COMMENT RESOLUTION FORM

Date:	6/1/2022		Disposition Codes:						
FHU Project Number	117253-08 EPC Reviews 2022		A. Accept Comment				E. Comment Conflicts with Previous Direction		
Project Name:	Sterling Ranch Road over Sand Creek Bridge		B. Delete Comment				F. Designer to Evaluate Comment		
Project Number:			C. Clarify Comment				G. Discuss Comment; Follow-up Required		
Client:	El Paso County		D. Disagree with Comment						
Designer:	Contech Engineered Solutions; KBJW								
Submittal:	Review 1		Other Review:				N/A		
Reviewer Comments			Designer/Consultant Response				Final Disposition

<b>MOONTZ BRYANT JOHNSON WILLIAMS</b> Formerly CBC Engineers	
<b>UPSTREAM HEADWALL DETAILS</b>	
Drawn By <b>DJH</b>	Date <b>4/18/22</b>
Approved By	Date
Scale <b>GRAPHIC</b>	Project No. <b>KBW-24879</b>
Rev. <b>-</b>	Sheet <b>3 OF 6</b>

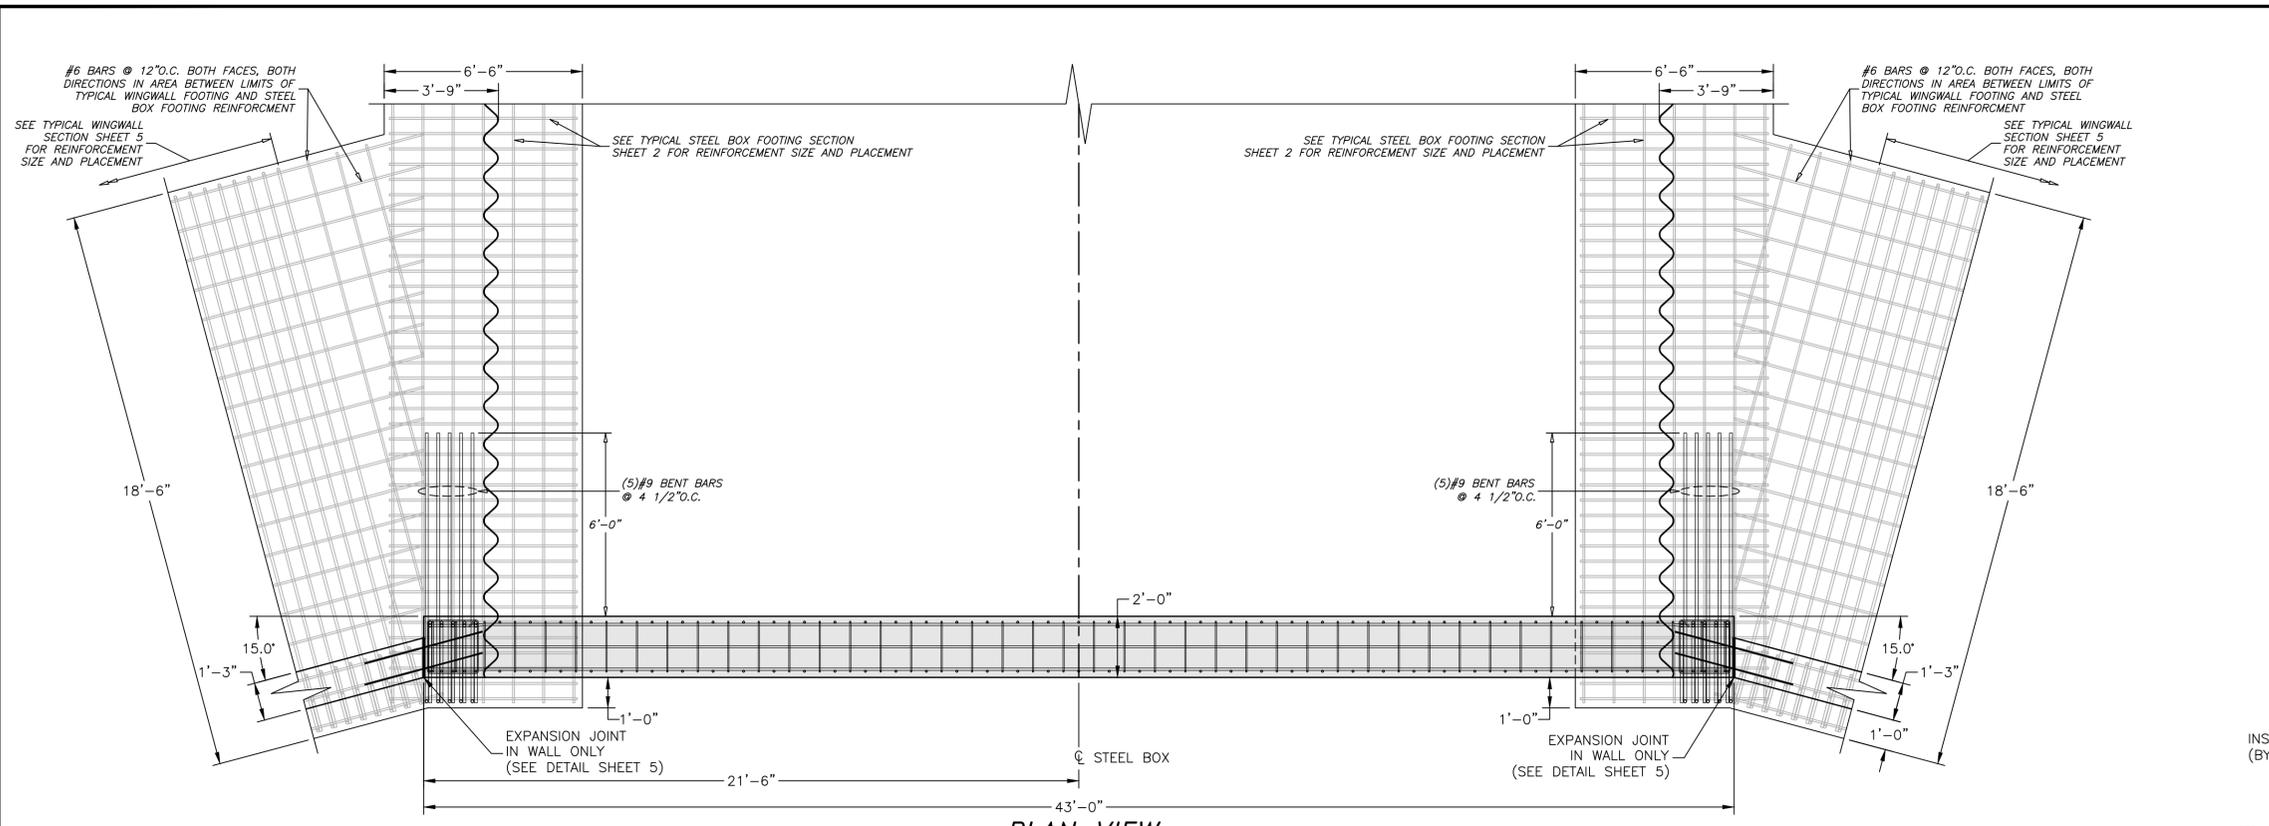
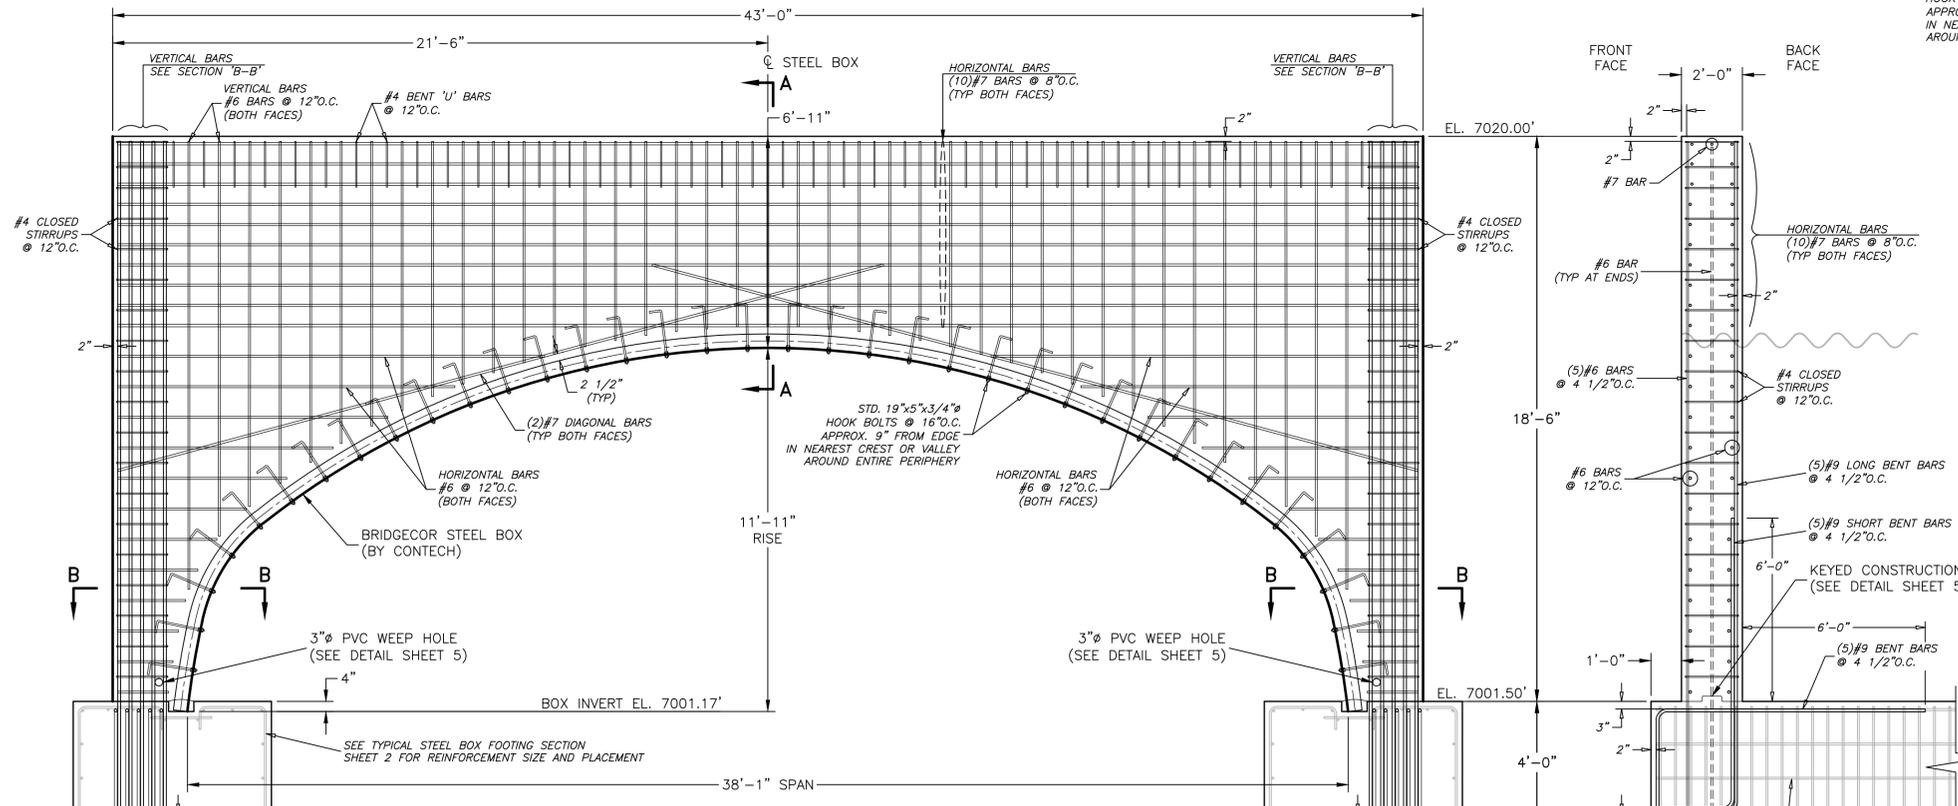
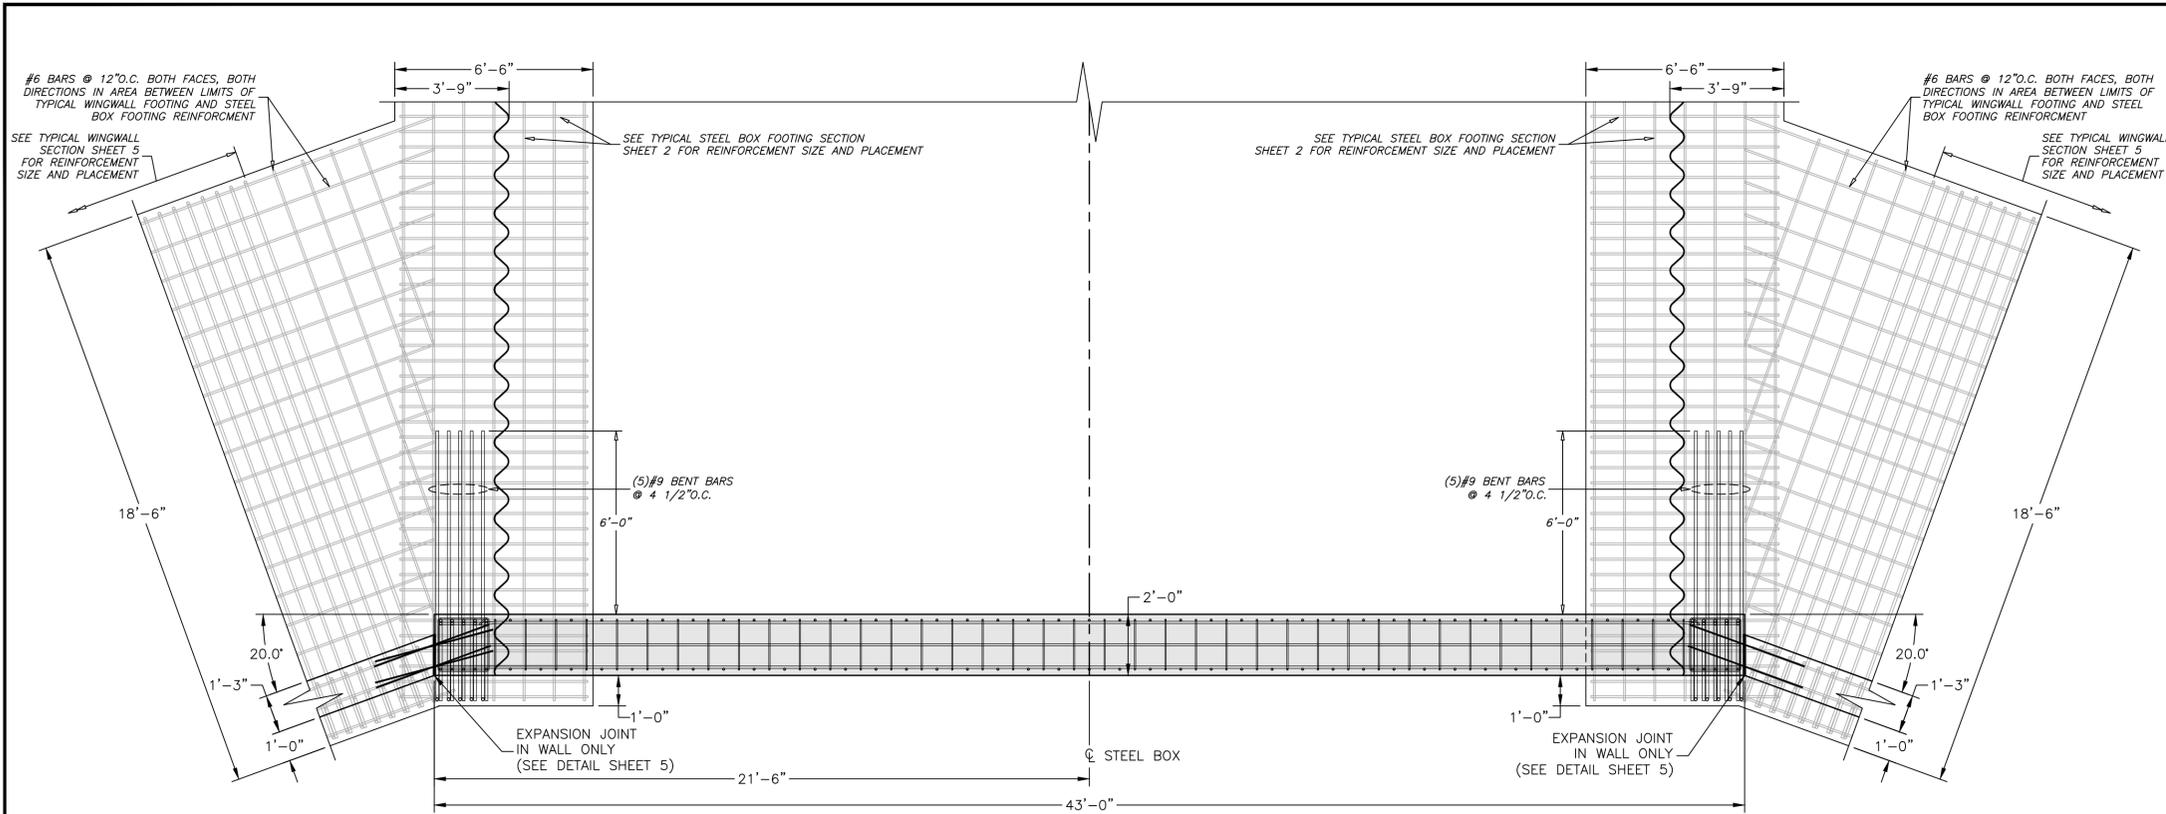
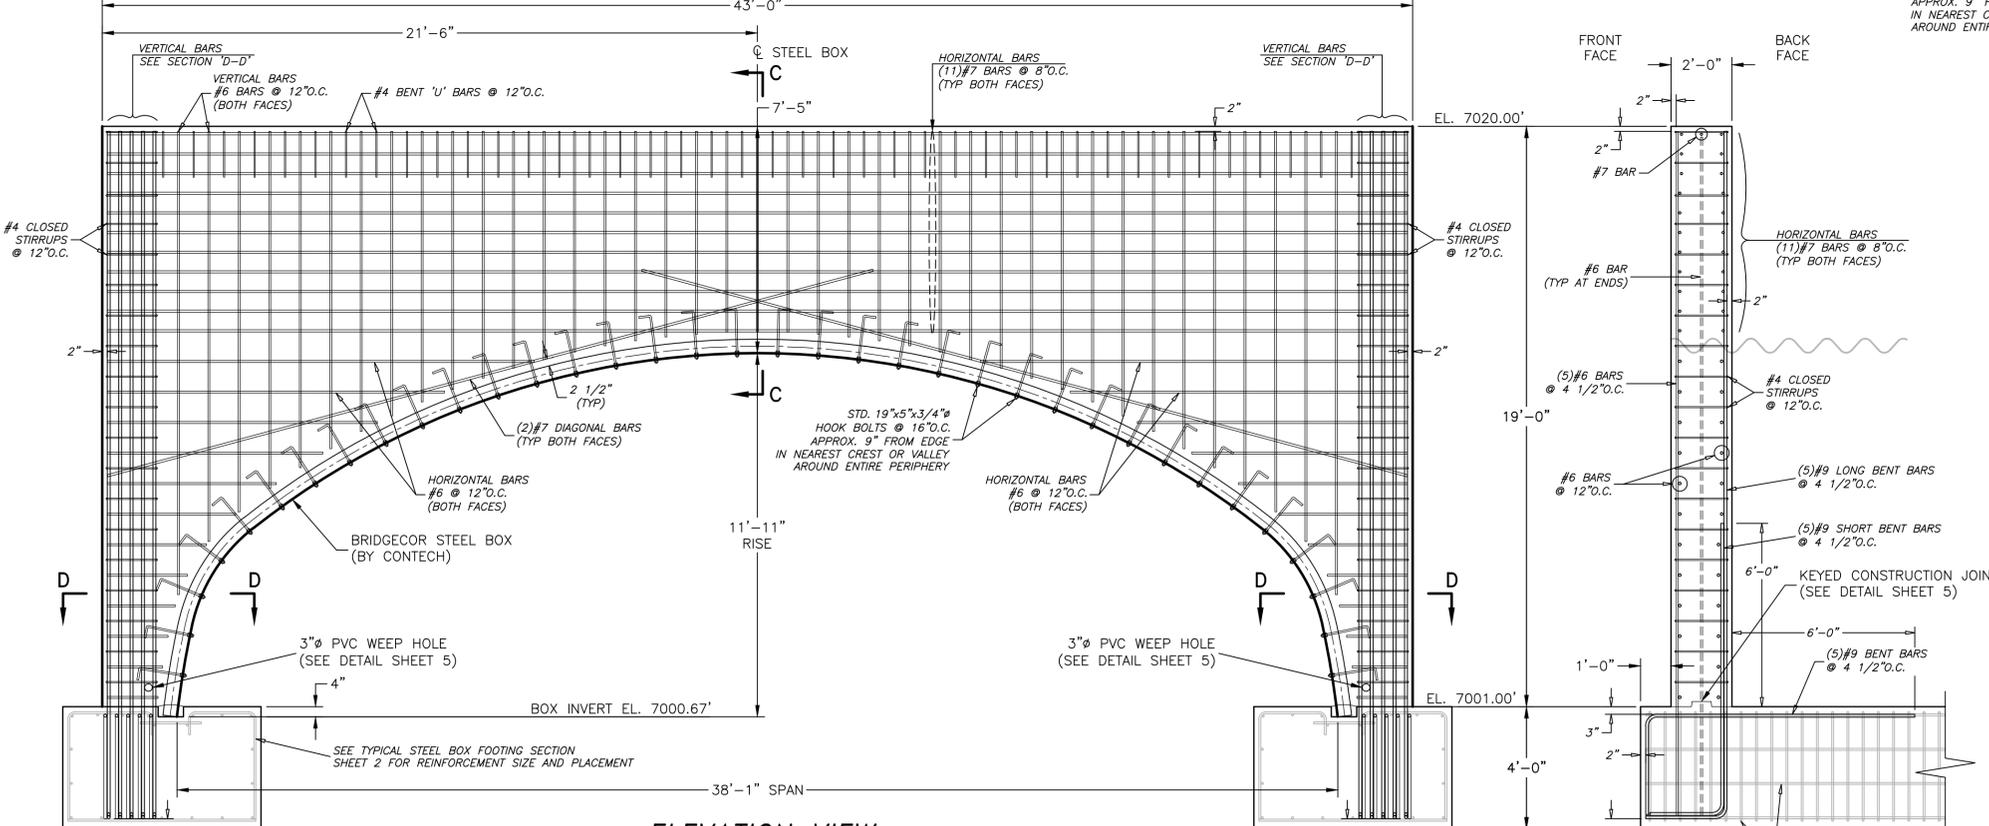
Comment No.	Reviewer	Sheet/ Page No.	Comments	Initial Code	Date	Response	Code	Date	Initials
1	CAO	CONTECH plan sheet 3 of 7	Headwall						
2	CAO	General calculations, CONTECH plan sheet 6 of 7	Confirm fill does not exceed 5'-0" per design. It is unclear from the Grading and headwall plans what the maximum fill height will be.						
3	CAO	KBJW plan sheets 3, 4	An indication of FG height below TOW at BF would be helpful in this section.						
4	CAO	KBJW Bridge Design Report pg 1	Addendum table with updated bearing capacities not provided for review. The referenced Entech Engineering report for Job No. 211647 for Briargate Parkway over Sand Creek does not indicate the bearing pressure noted here. Please provide addendum/report for verification.						
5	CAO	KBJW Bridge Design Report pg 2	Cannot confirm with submitted Entech Subsurface Soil Investigation report (revised, dated March 24, 2022) nor referenced Entech report for Job No. 211647. Please provide for verification.
